bulletin no. **B -61**

description Conversion of lower Level Storage Rooms to Fitness Rooms

attachments Revised Life Safety Plan G002R dated 050918
Fire Alarm modification SKE-22, Lighting Modification SKE-23, HVAC Modification SKM-08

WAYNFLETE LOWER SCHOOL ADDITION & RENOVATIONS

Drawing file: 1.  Original Plans / 100 WFLS MH101_Mechanical Plan Lower Level.pdf

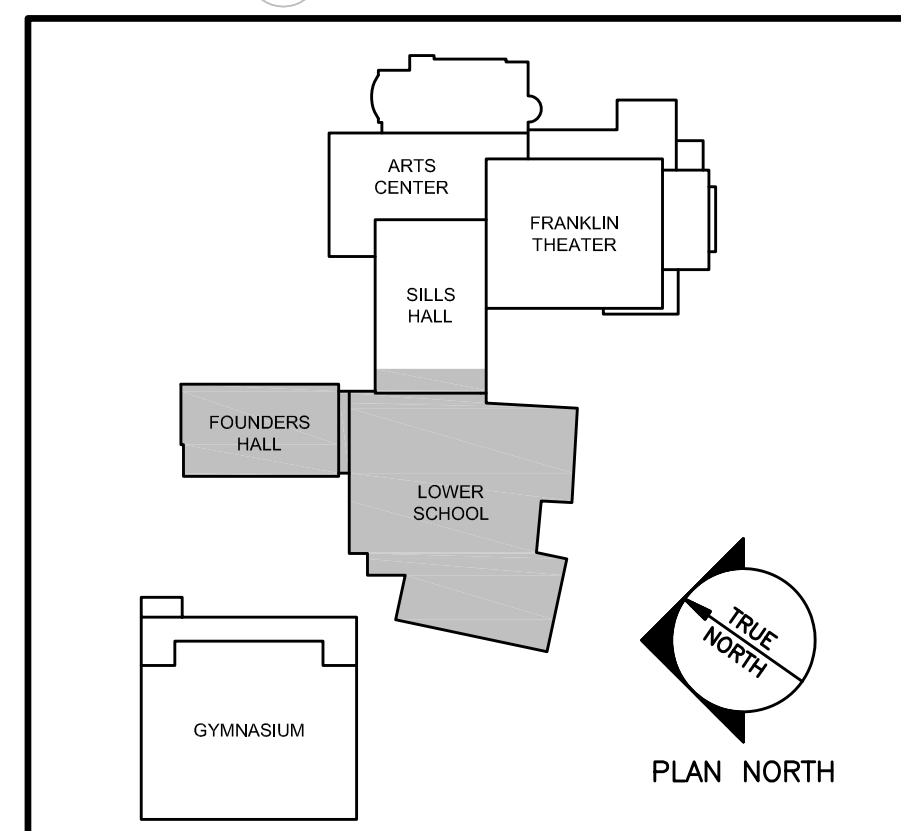
SKM-08

EXERCISE ROOMS - A5 - SHEET MH101

6 PRICE MODEL SDV5-8, TYPICAL OF 4.

7 2-TON DUCTLESS SPLIT AT 9'-0" A.F.F. +/- . ROUTE CONDENSATE TO SINK TRAP. SEE ATTACHED CUT SHEET.

SKM-09	REVISED KEYED NOTES ~ A5 - SHEET MH101 - EXERCISE ROOMS		 Allied Engineering Structural Mechanical Electrical Commissioning 	160 Veranda Street Portland, Maine 04103 T: 207.221.2260 F: 207.221.2266 Web: www.allied-eng.com
	WAYNFLETE LOWER SCHOOL ~ ADDITION AND RENOVATIONS			
	SCALE: 1/8" = 1'-0"	PROJ NO: 15051		
	DATE: 04-20-2018	CAD FILE: 15051M.dwg
